Rezoning Petition Review

Date of Review: May 20, 2020 (**Revised August 26, 2020**)

Rezoning Petition #: 20-57

Location of Property: Approximately 92 acres located west of I-485, on the north side of Old Dowd Rd and east of Sam Wilson Rd.

Schematic Site Plan Rezoning Petition #2020-057

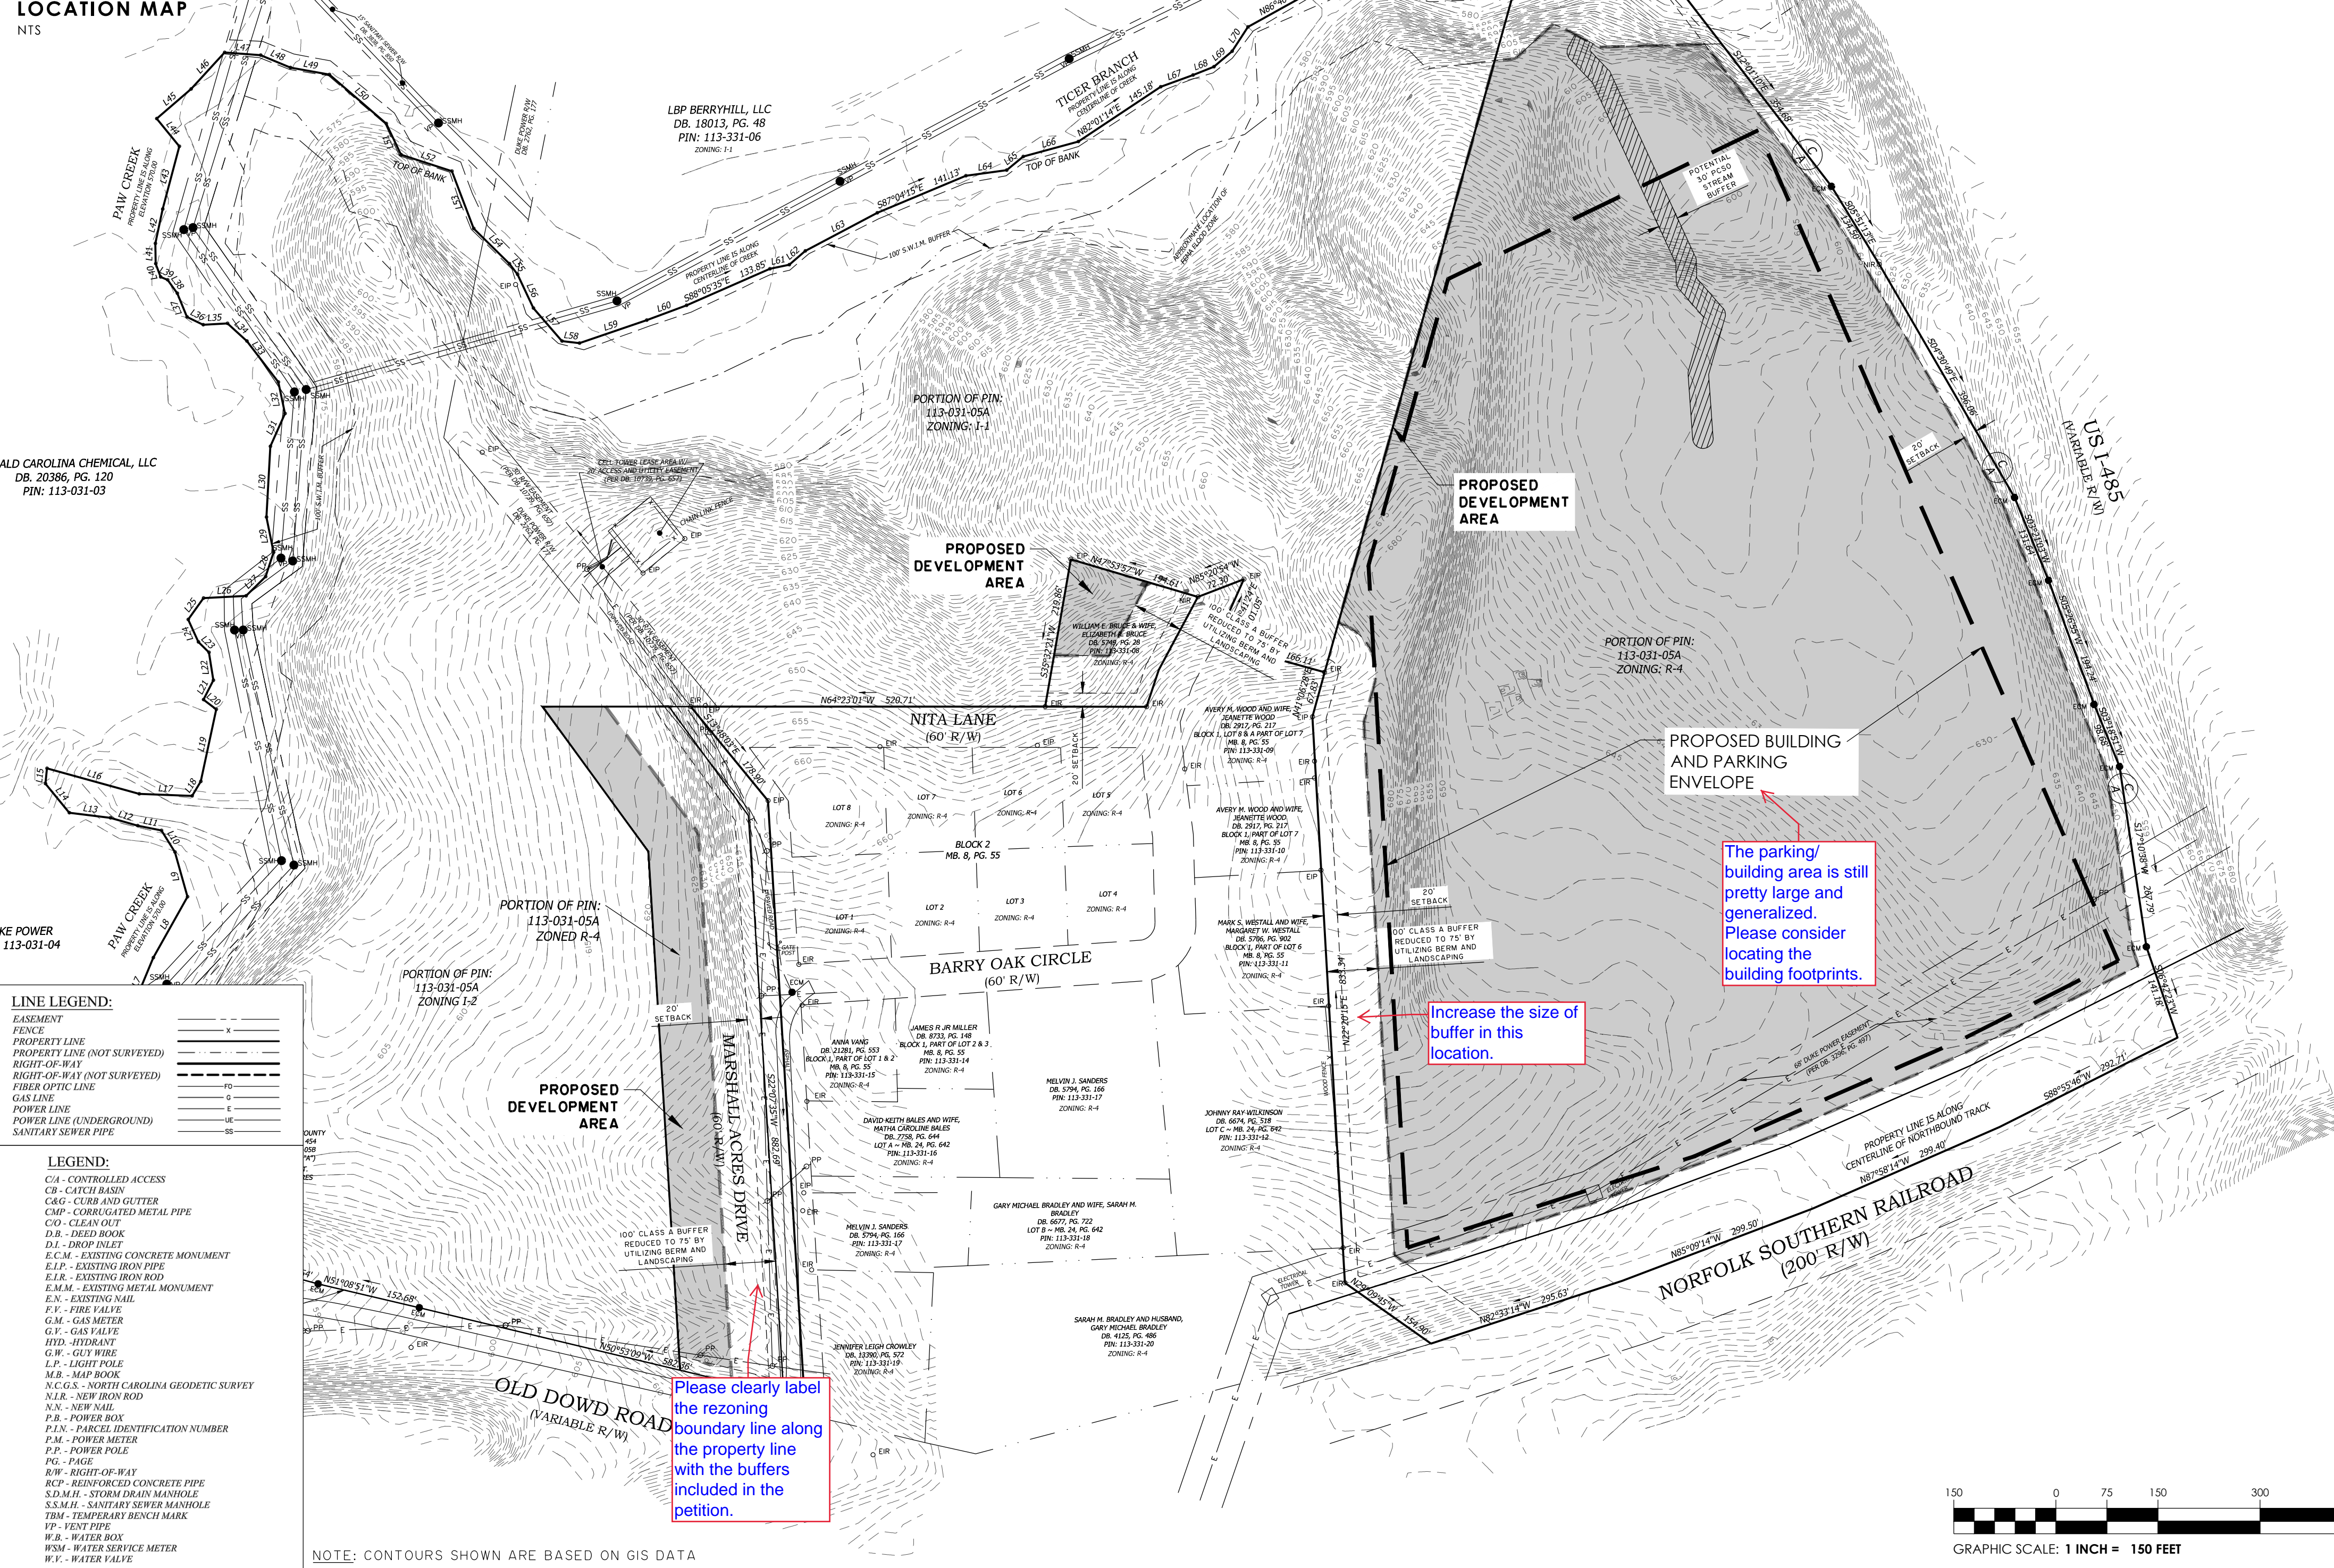
Due to revisions (6/19/20): The rezoning plan sheet indicates a 100-ft SWIM Buffer on site. Please revise buffer label to read “100-ft SWIM/Watershed/PCSO Buffer.”

Please include the following note under *Environmental Features*:
Development within the SWIM/PCSO Buffer shall be coordinated with and subject to approval by Charlotte-Mecklenburg Storm Water Services and mitigated if required by City ordinance. Stream Delineation Reports are subject to review and approval by Charlotte Storm Water Services.
